About the application

Application number: 2021/90702	
What is the application for?:	Variation conditions 2 and 3 on previous permission 2018/94167 for erection of d
Address of the site or building:	adj, 27, Riley Park, Kirkburton, Huddersfield, HD8 0SA
Postcode:

Proposed Site Plan 1:200

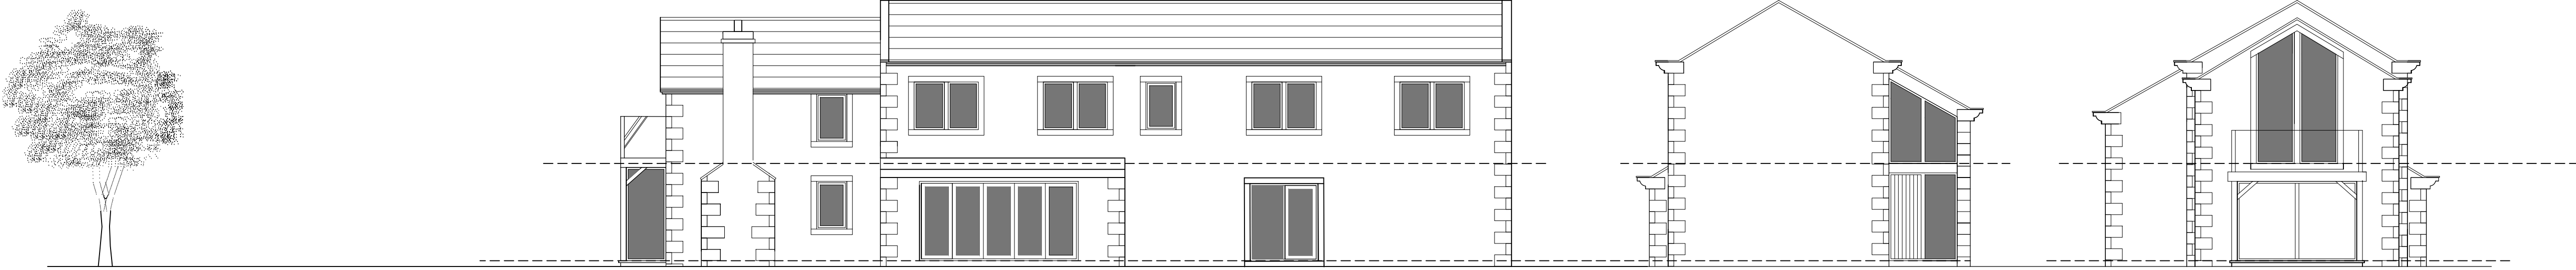
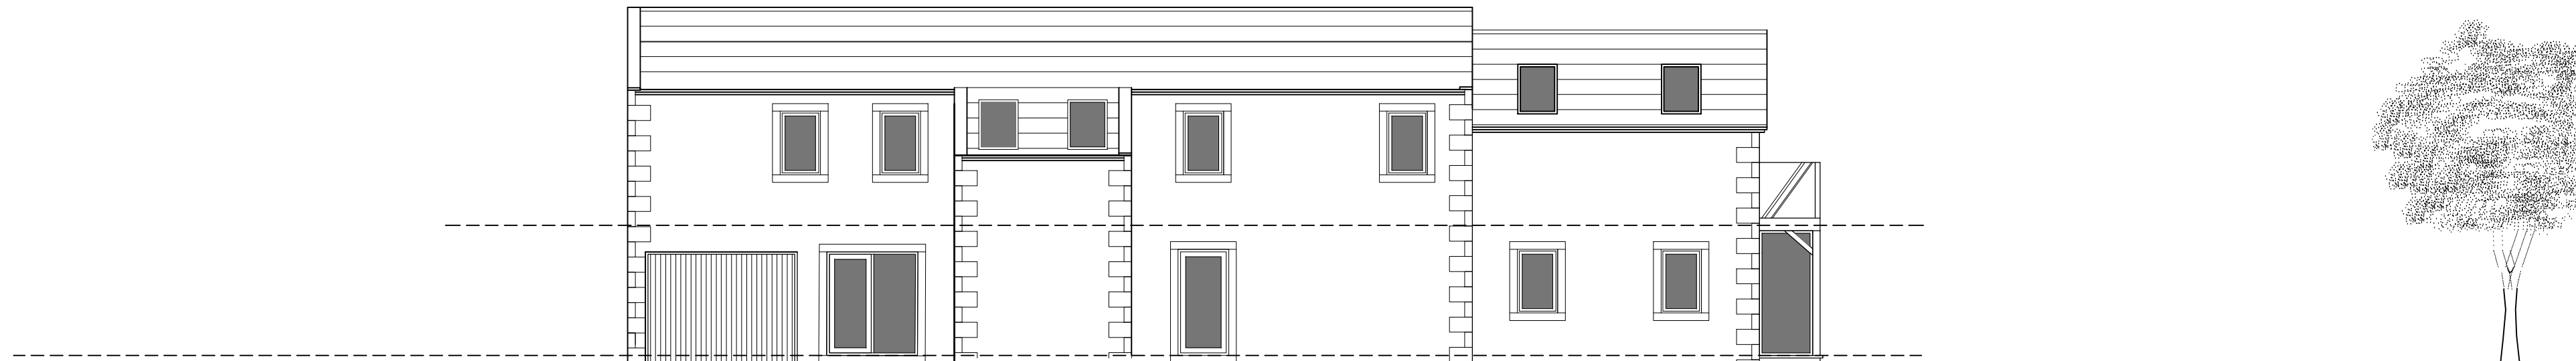
I have serious concerns regarding the stability of the banking on which this proposed development sits. It is clearly unstable and there is the potential of collapse and landslip. The building is proposed to be built very close to the 'cliff edge' of the banking. The proposed development being significantly larger raises increased concerns about safety and stability of the land to be built on. The site is on an area of previous coal mining and we have witnessed boulder movement during recent intrusive groundworks on the site. This movement has continued to happen since this work was undertaken. I am not sure this site is safe to develop and as we live 30 feet below the top of the banking it is concerning that slippage / land slide would impact on our safety. The site borders a river and at this point is in flood zone three therefore any slippage will be a potential risk to the flow of the river. The trees on the banking are likely to be providing necessary structure for the soil and stone slabs and it is not clear which of these are to be felled.
